RE: OAKDALE SOUTH ESTATE (SSD6917 MOD7) – RESPONSE TO SUBMISSIONS

Oakdale South SSD6917 MOD 7 – Response to Submissions

Stage 1 Development Works
Landscape Plan

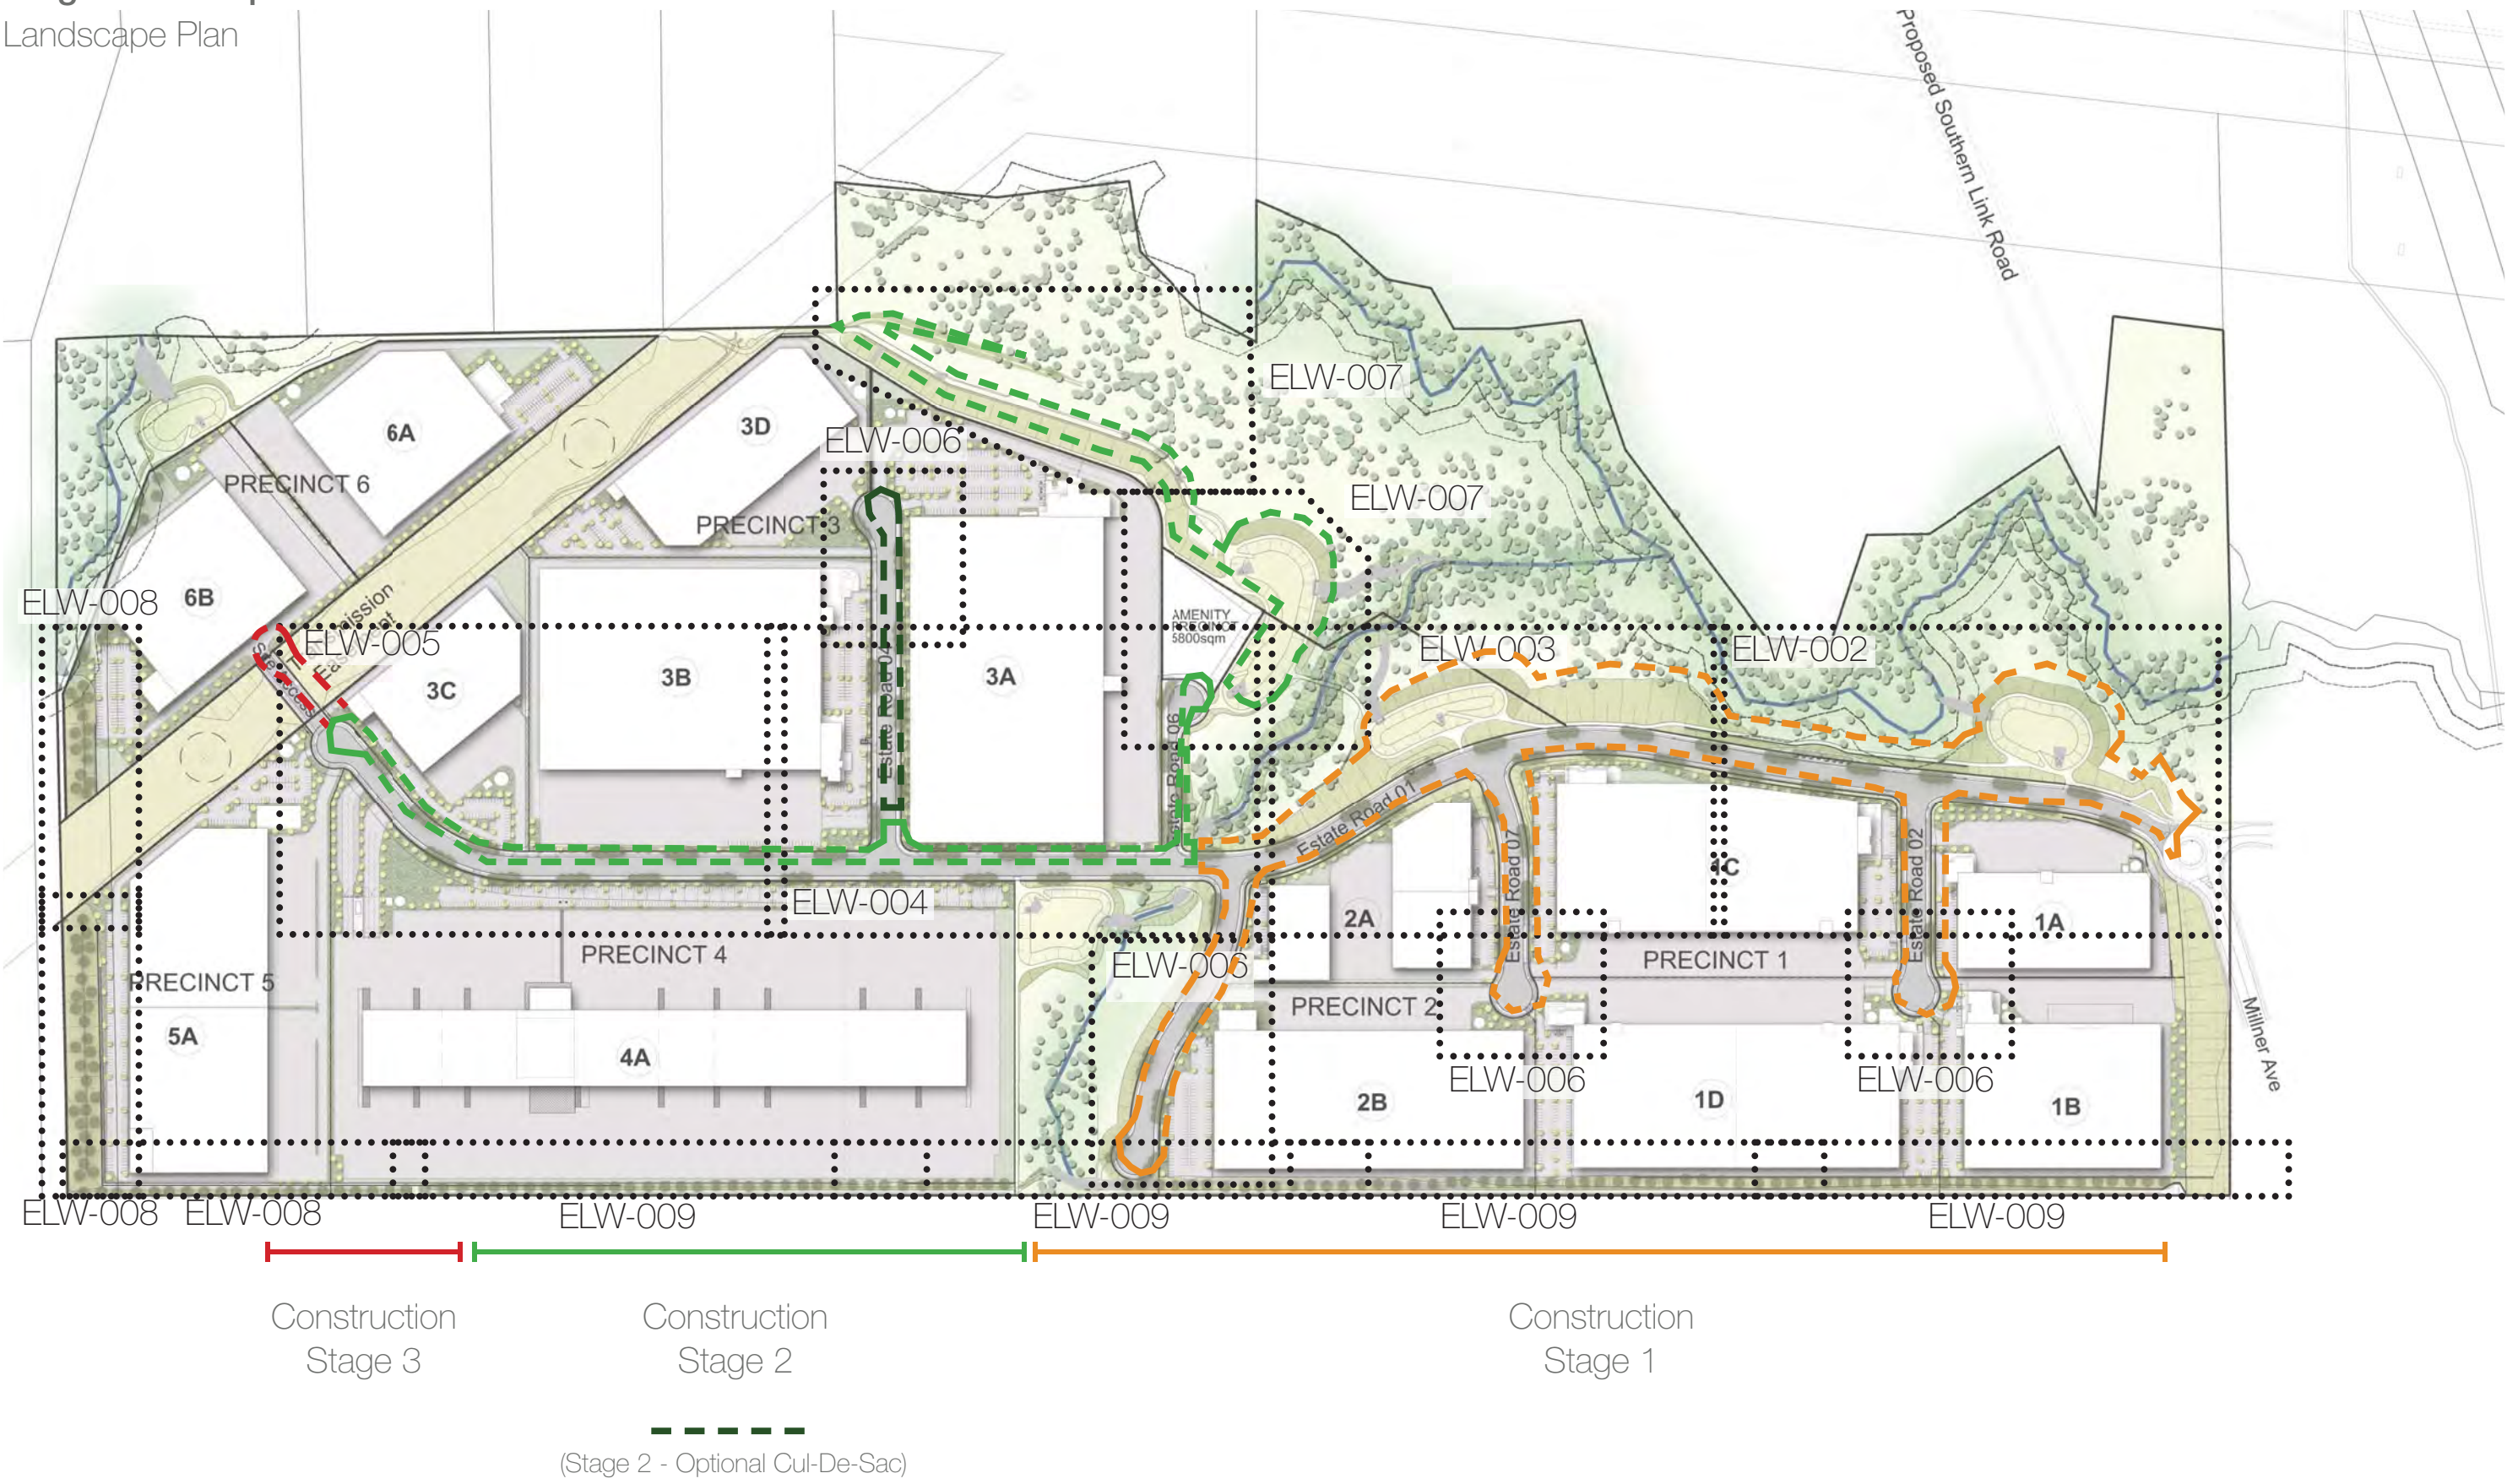
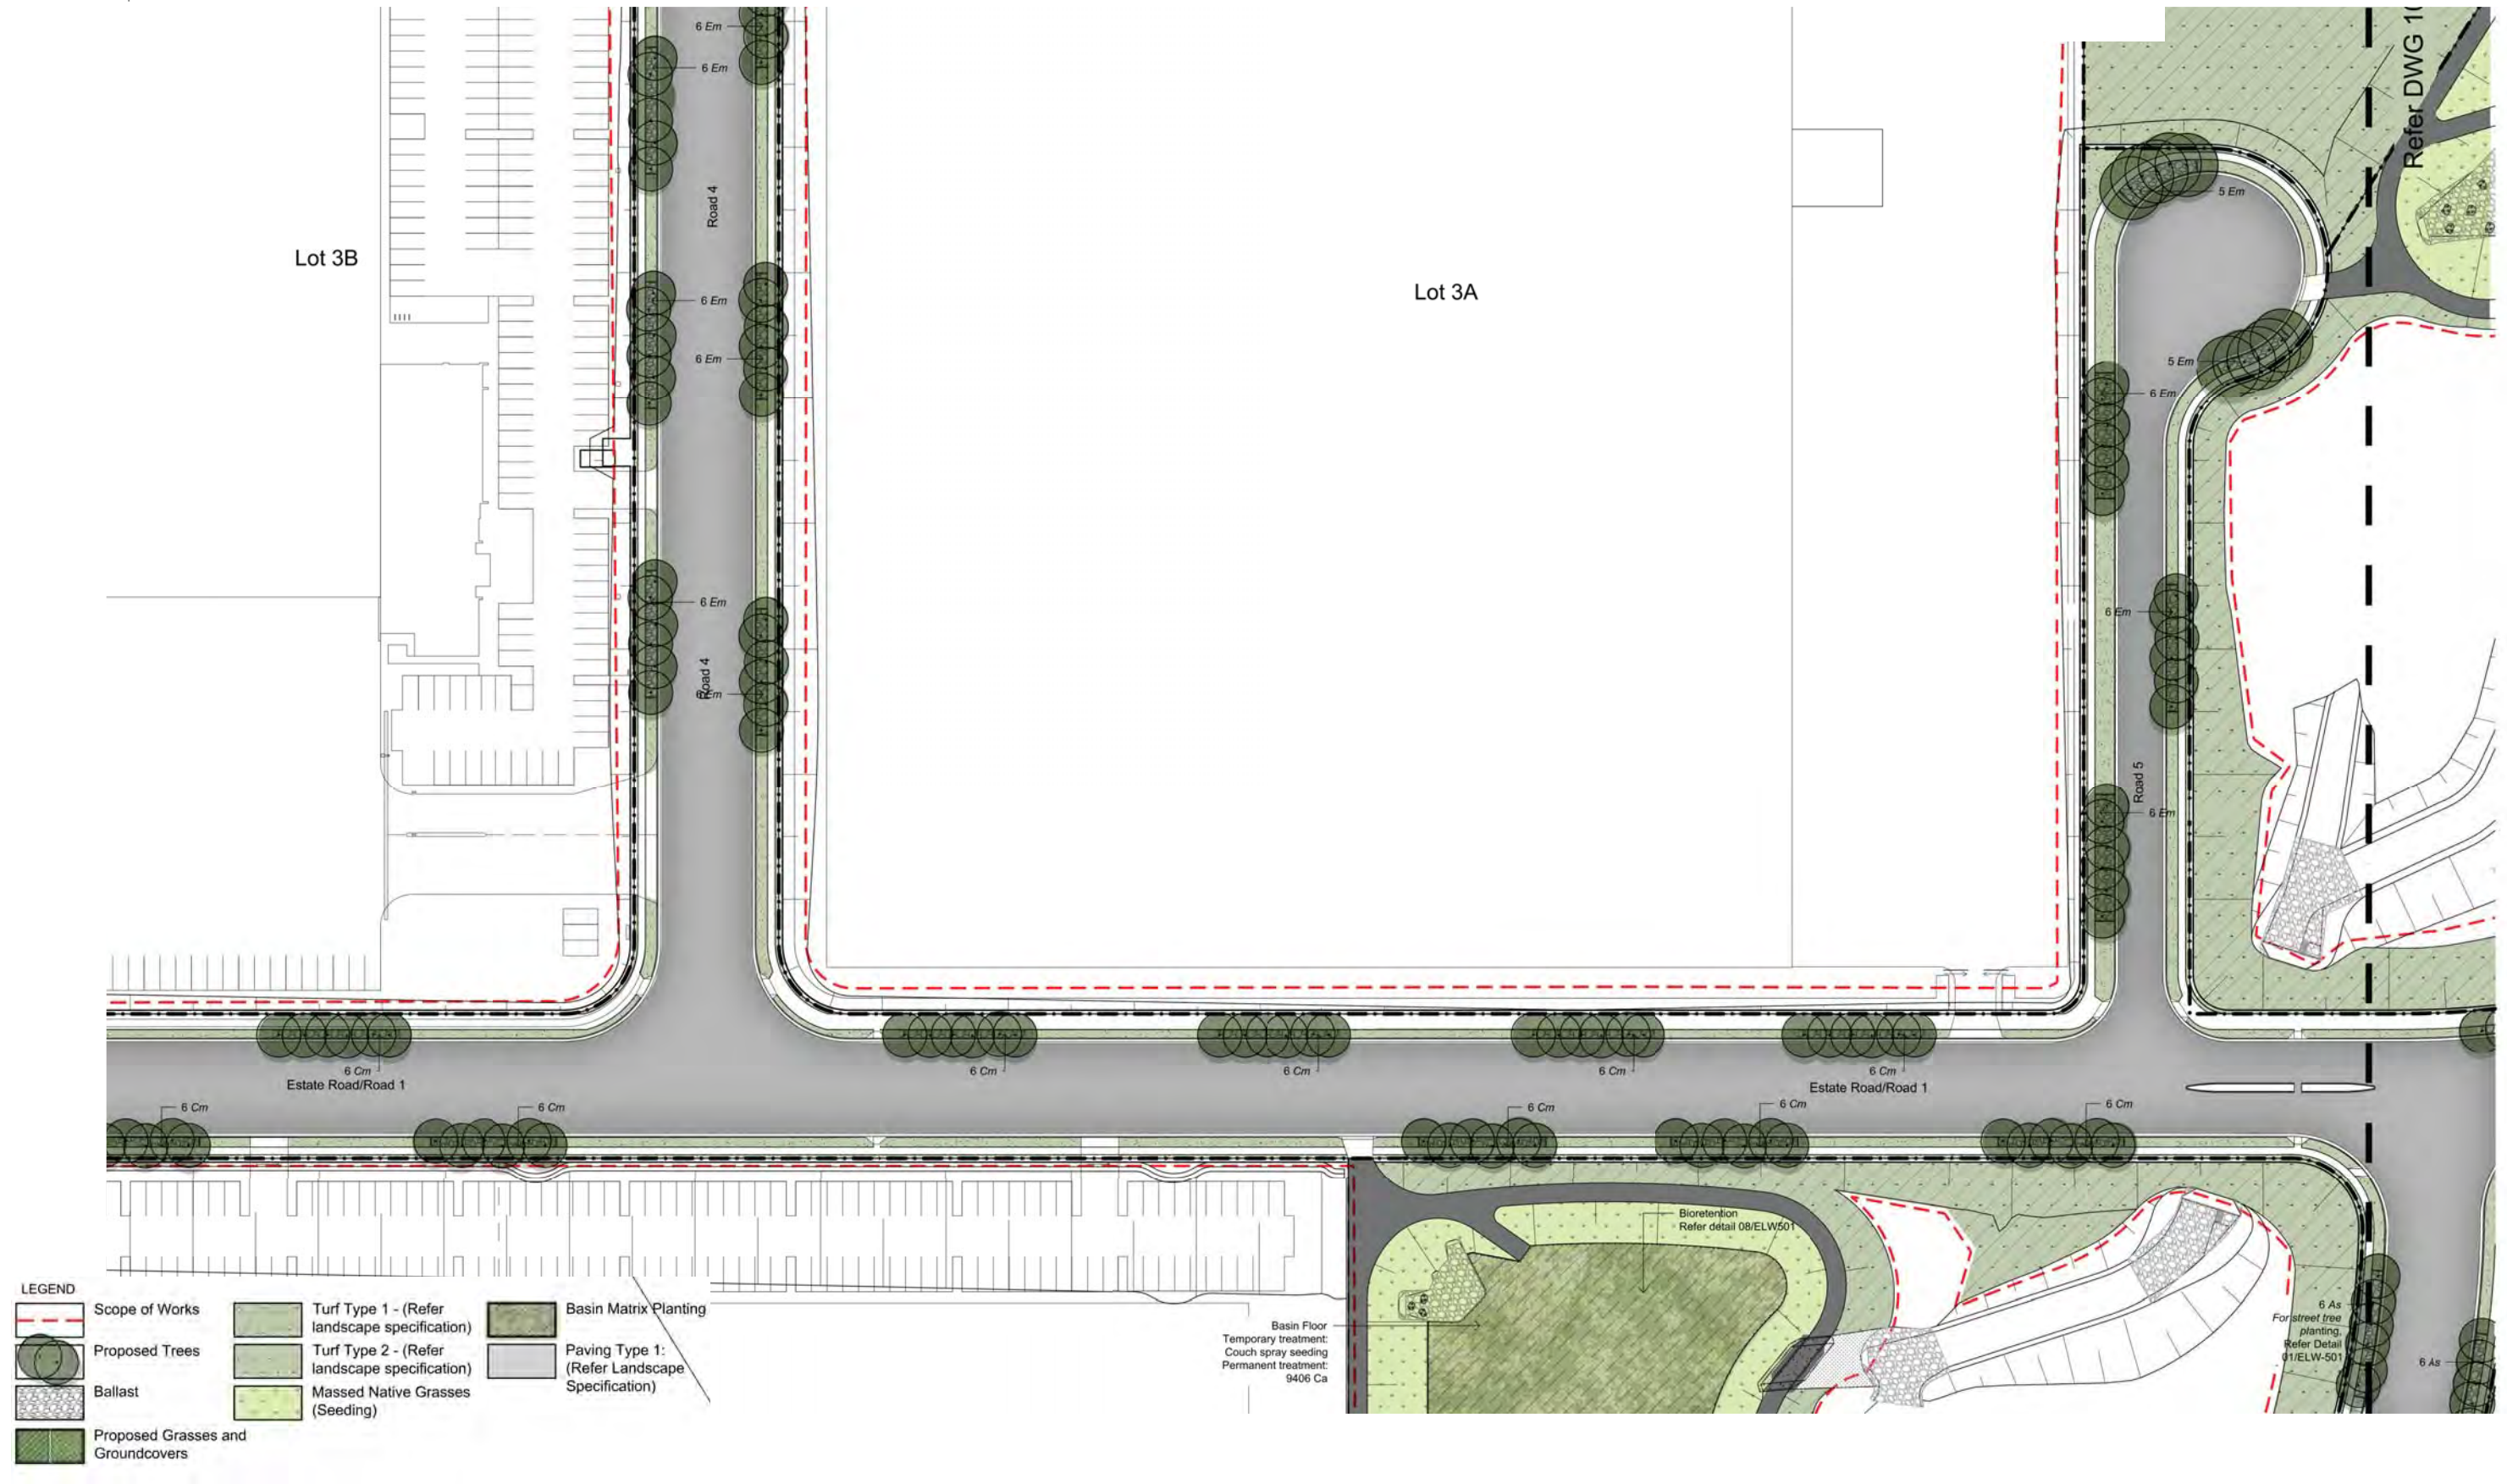
Matters Raised	Applicant consideration of matter/response
Department of Planning	
Concerns are raised by Council regarding the potential lack of adequate landscaping along the property boundary and associated visual impacts.	Noted – please see response below to Council’s submission regarding landscaping.
The Vegetation Typologies plan submitted should reflect the re-alignment of the Ropes Creek Tributary.	Noted – this has been updated as requested (refer to attached updated Vegetation Typologies plan – Appendix A).
The Department notes the site is subject to a current Planning Proposal to amend the E2 Environmental Conservation zone boundary. As the proposed hardstand area is prohibited within the zone, the Department cannot complete an assessment of the development application until the lands have been re-zoned.	Noted - it is understood that MOD7 will not be determined before the E2 / IN1 rezoning is finalised.

Penrith Council	
While the rezoning may be appropriate given the approved road configurations, the proposed extent of additional hard stand area now proposed is not considered to be appropriate at this intersection and an improved landscape setback between the property boundary and car parking areas should be required.	<p>It is unclear which area is “between the property boundary and car parking areas.”</p> <p>The proposed landscaping in the north-eastern corner of the Sigma (Lot 3A) (corner of estates Rd 01 & 06) is considered appropriate as it is consistent with the concept boundary landscaping, particularly street tree planting, applied to and approved for Oakdale South. The boundary strands of trees occur every 7 metres (Estate Rd 01) or 9 metres (Estate Rd 06), which provide appropriate visual screening of the facility from the road.</p> <p>It should be noted that SSD7719 MOD1 seeks the increase of turf and soft landscaping setback in the north-eastern corner of Lot 3A from that originally approved under SSD7719, thereby enhancing the presentation of this corner. Visually, the hardstand surface has substantially the same appearance as the approved ballast (gravel) it replaces (approved in SSD7719 for the E2 zoned area), and the visual impact of the hardstand area is mitigated and enhanced by the additional turf and soft landscaping in this area. The landscape treatment to this area is therefore considered appropriate.</p>

<p>Updated planting, to address the corner and landscape the edges</p> <p>Expansion of hardstand area replacing ballast and increasing landscaped setback up to the corner</p>
<p>The proposed plans provide for a 2.5m setback to Road 06 which is inadequate given the location of this site. The corner of the site (south east) requires an embellished landscape setback to frame the intersection of Estate Road 6 and Estate Road 1 which is planned to be embellished to the east and south. The extension of the hard stand out to the intersection area does not suitably respond to the contextual planned landscape character of this intersection, and an increased setback should be provide.</p>	<p>The proposed 2.5m landscape setback along the northern boundary to Estate Rd 06 remains consistent with that approved under SSD6917 and SSD7719, with no reduction proposed. As discussed above, the street trees along the frontage provides appropriate visual screening for the development, and the landscape setback along Estate Rd 01 is increased from that originally approved under SSD7719, thereby enhancing presentation.</p>

<p>It is also recommended that the access driveway to Estate Road 01 be relocated to Estate Road 6 to provide an unbroken landscape connection along Estate Road 01 for the full width of the lot. This would suitably address the landscape character of this road as well as sites relationship to the E2 zoned land further east. This option may still enable the proposed 2.5m landscape setback to Road 06 further north of the intersection, away from the intersection which is the primary view corridor within the development.</p>	<p>Operationally Sigma have confirmed it is not suitable to have the access driveway located on Estate Road 06 rather than Estate Road 01, due to swept path and grade separation limitations.</p>
<p>The remainder of the issues included in Penrith Council's letter of 6 March 2018 concerns SSD7719 and not SSD6917 MOD7, and will therefore be addressed under separate cover in the Response to Submissions for SSD7719.</p>
